Our Ref : Cochlear Response to Agency Submissions

COCHLEAR LTD RESPONSE TO AGENCY SUBMISSIONS

Thank you for your recent comments in relation to the proposed development of the new Cochlear facility at Macquarie University. Following receipt of additional comments from the Department of Planning, Ministry of Transport, Roads and Traffic Authority and Ryde Council, we are pleased to provide you with the following consolidated response.

COCHLEAR GLOBAL HEADQUARTERS
WAREHOUSE SERVICE AREA ACCESS
WAREHOUSE SERVICE AREA ACCESS
12.5m SINGLE UNIT VEHICLE
CE001063 Figure 002
P.J.T. 08-04-08

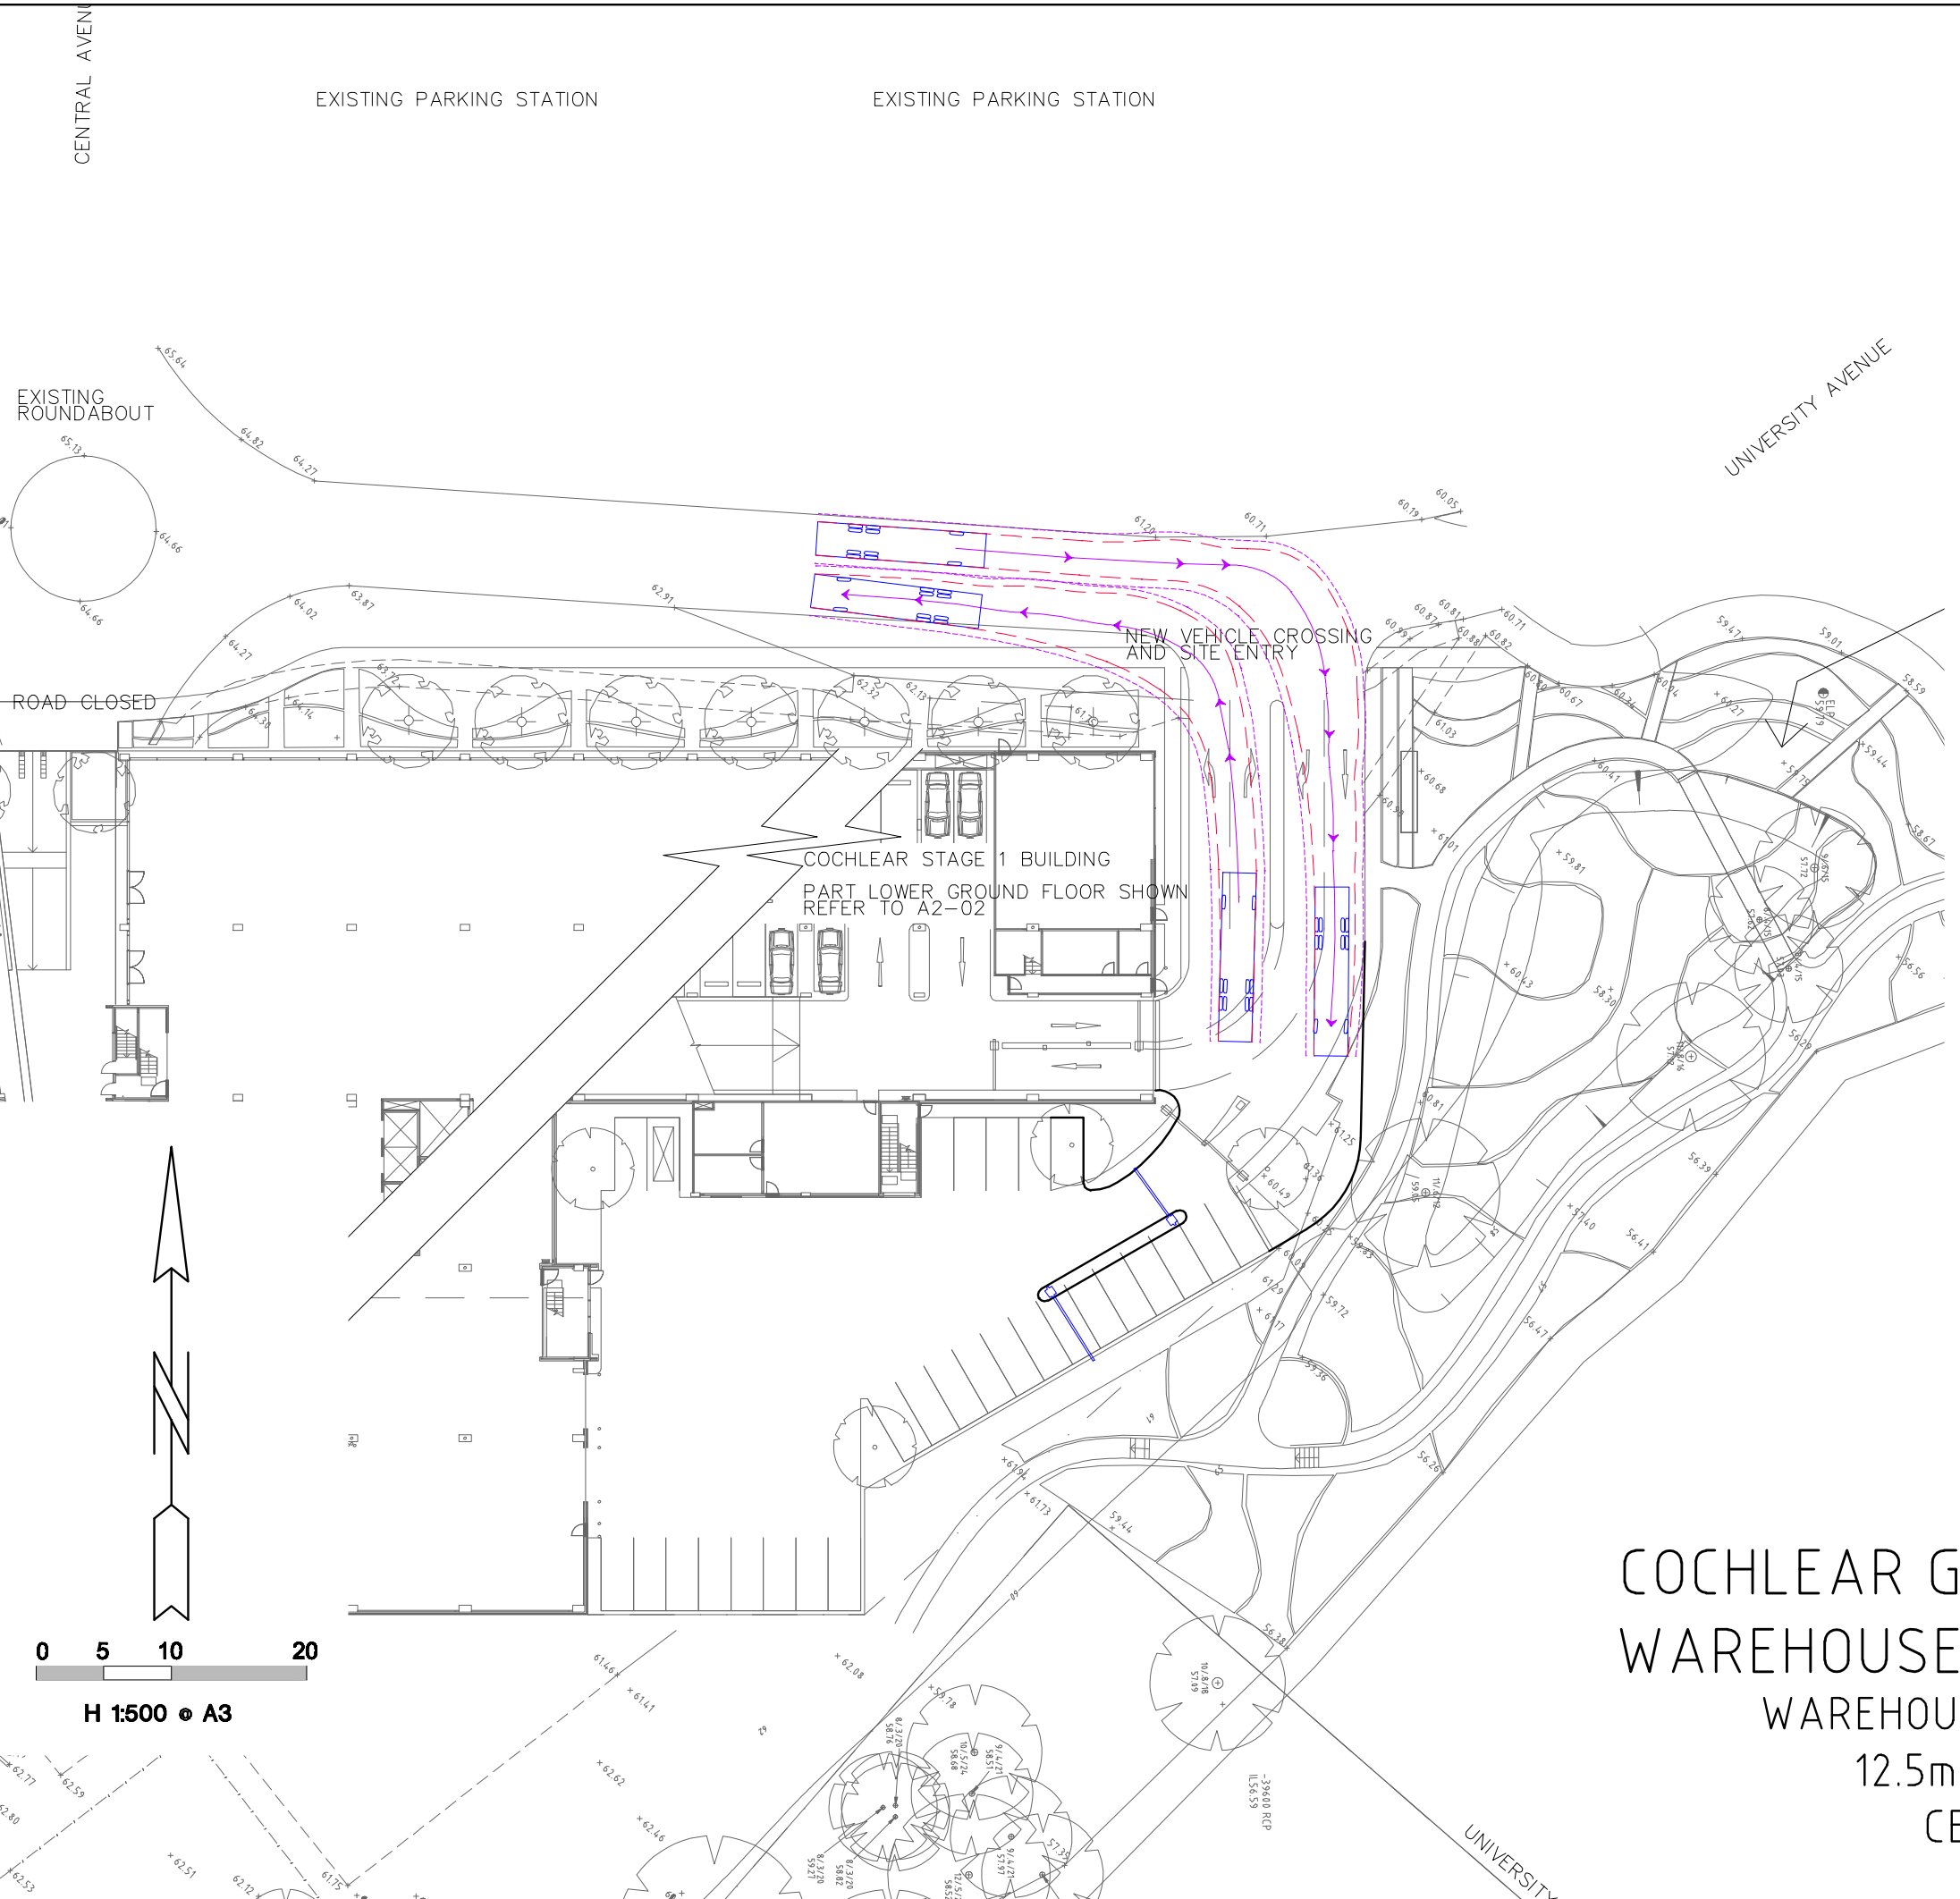
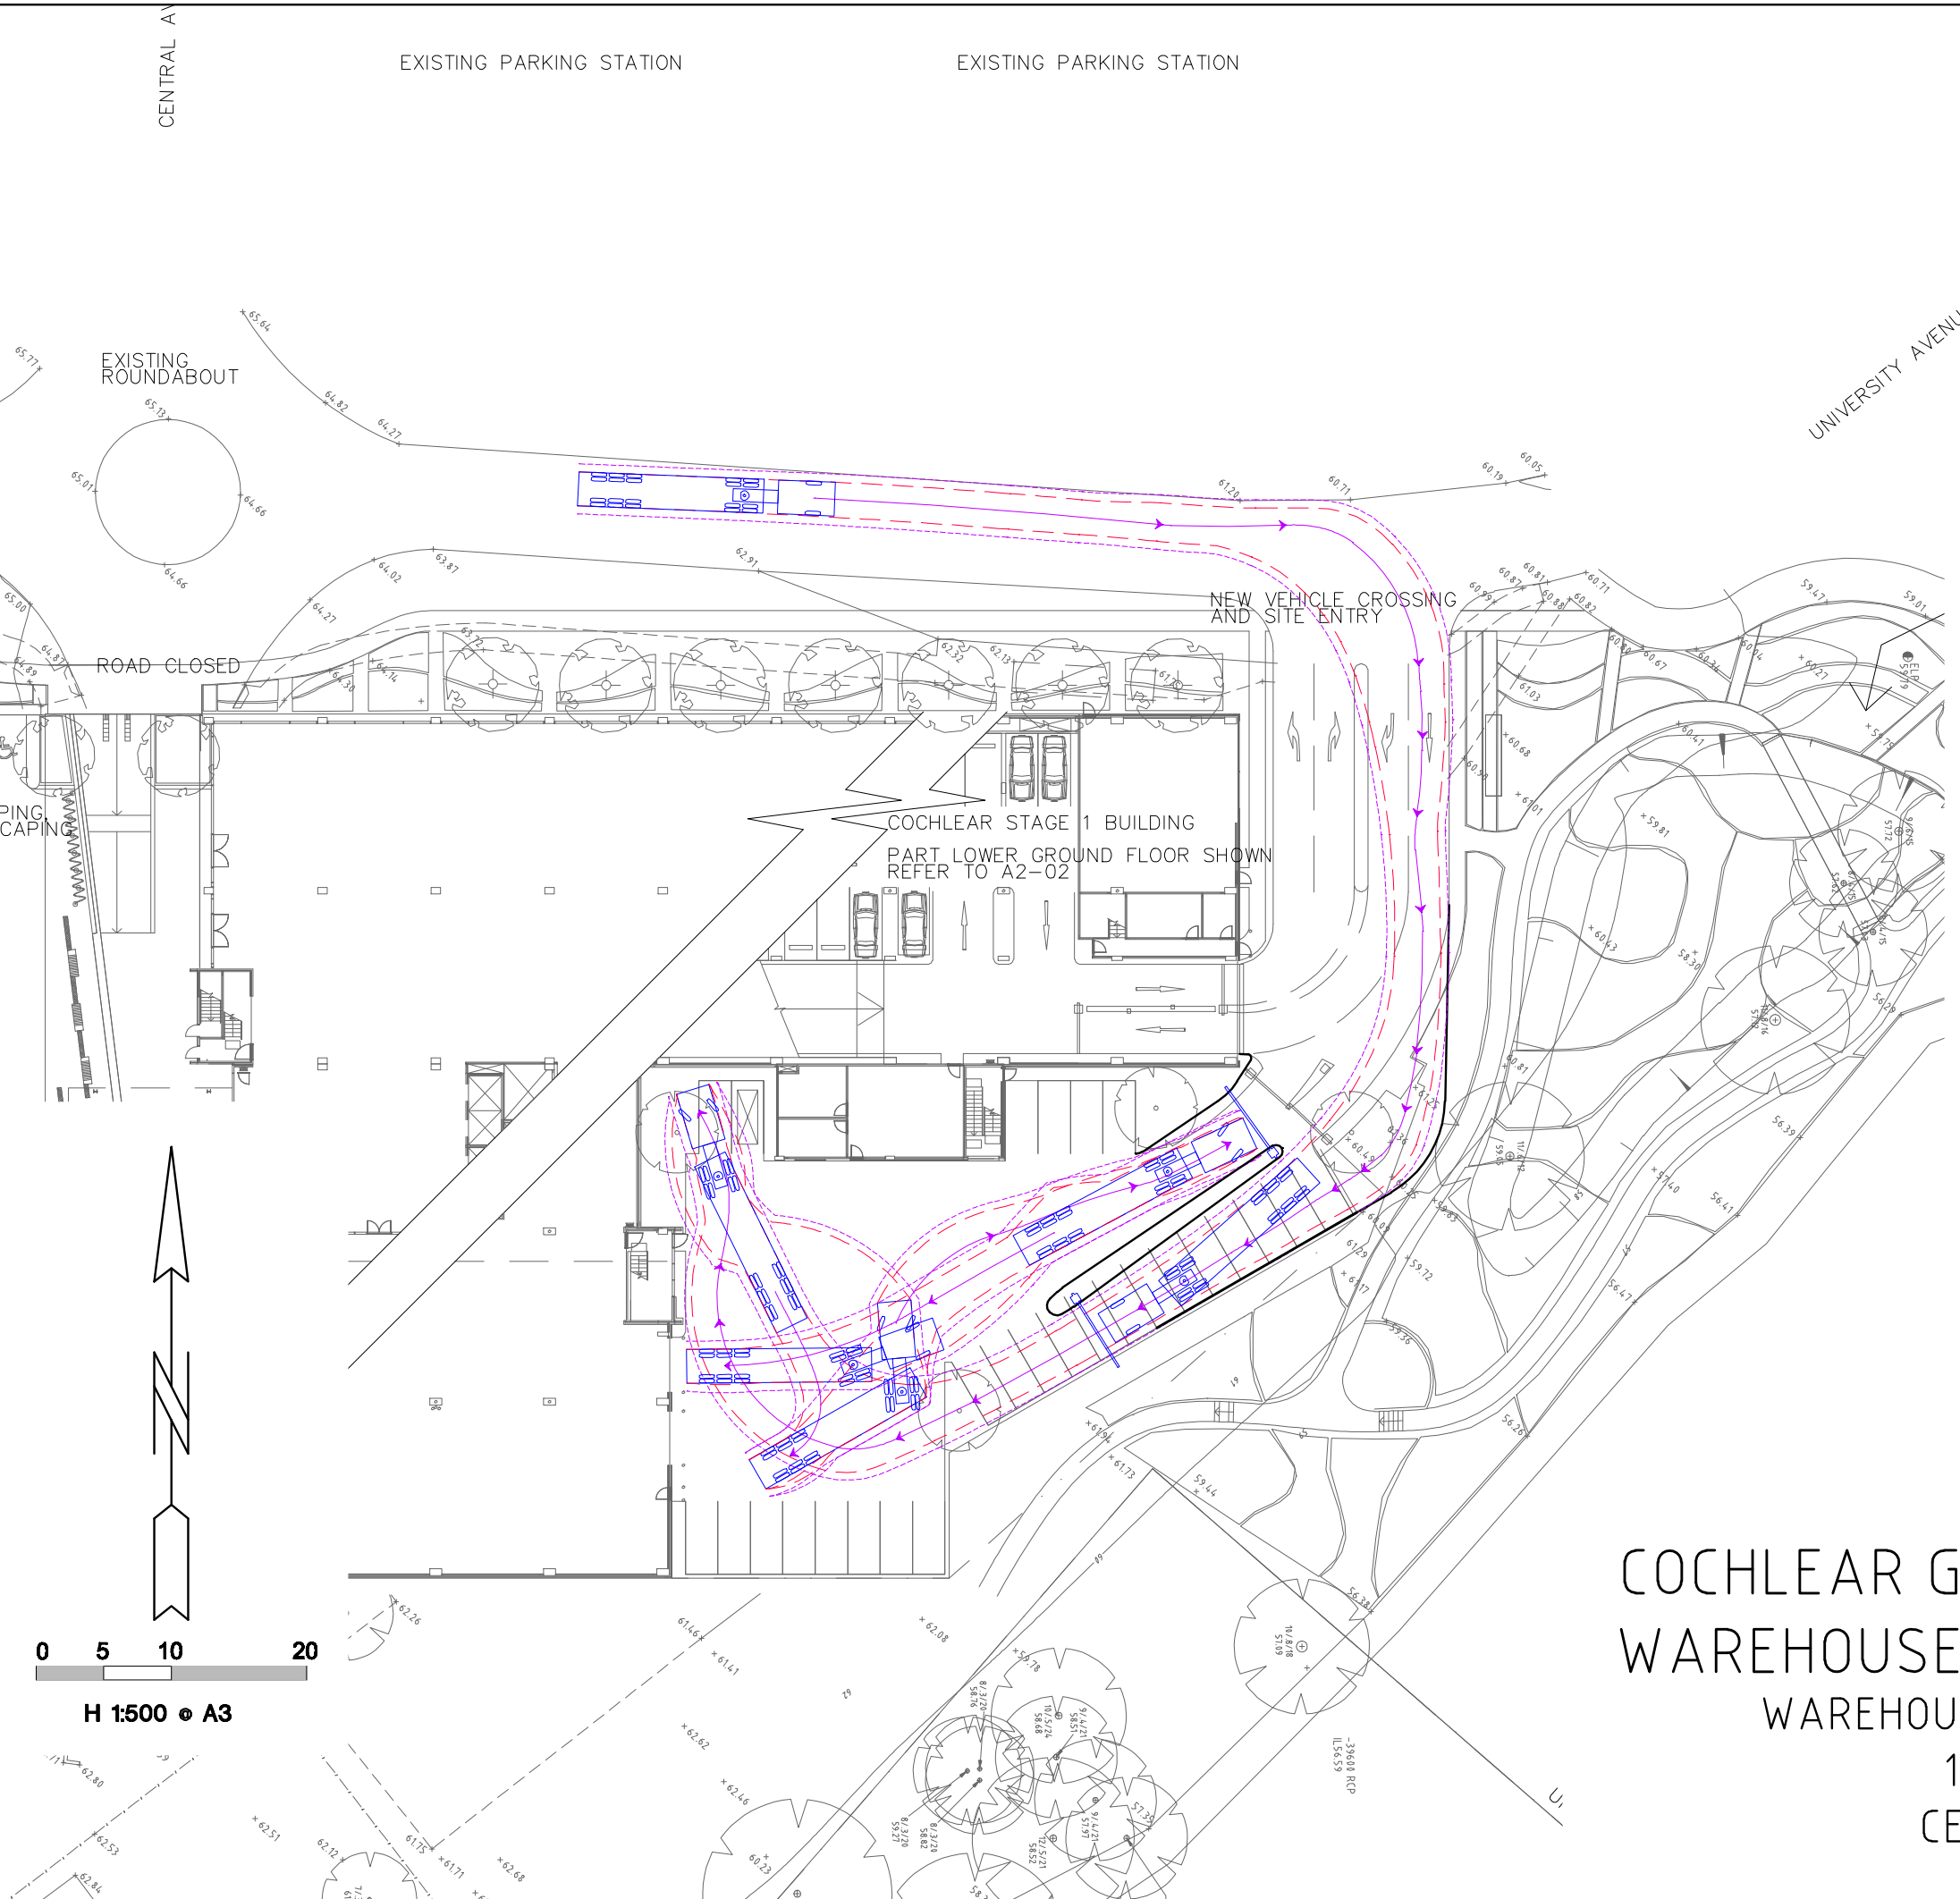
MoT5: *The need to retain the existing roundabout at the intersection of University and Central Avenues is questioned, and if removed would enable a more prominent and functional bus stop with direct connection to the main pedestrian concourse within the proposal.*

The removal of the subject roundabout at University Avenue/Central Avenue and relocation of the bus stop, with associated bus stop pedestrian facilities, will be investigated through the MUCP TMAP Review. Recommendations in relation to internal road circulation within the University and provision of bus only links and improved pedestrian facilities have been put to the MQ as part of the agency stakeholder submissions for the MUCP. MQ will be considering these recommendations as part of the TMAP review.

It should also be noted that currently the roundabout serves not only traffic travelling along University Avenue and access to the surface car park on the subject site but it also provides access to the multi-storey car parks on the northern side of University Avenue. It is unlikely that the intersection will operate adequately as a priority-control T-junction until the multi-storey car parks are removed.
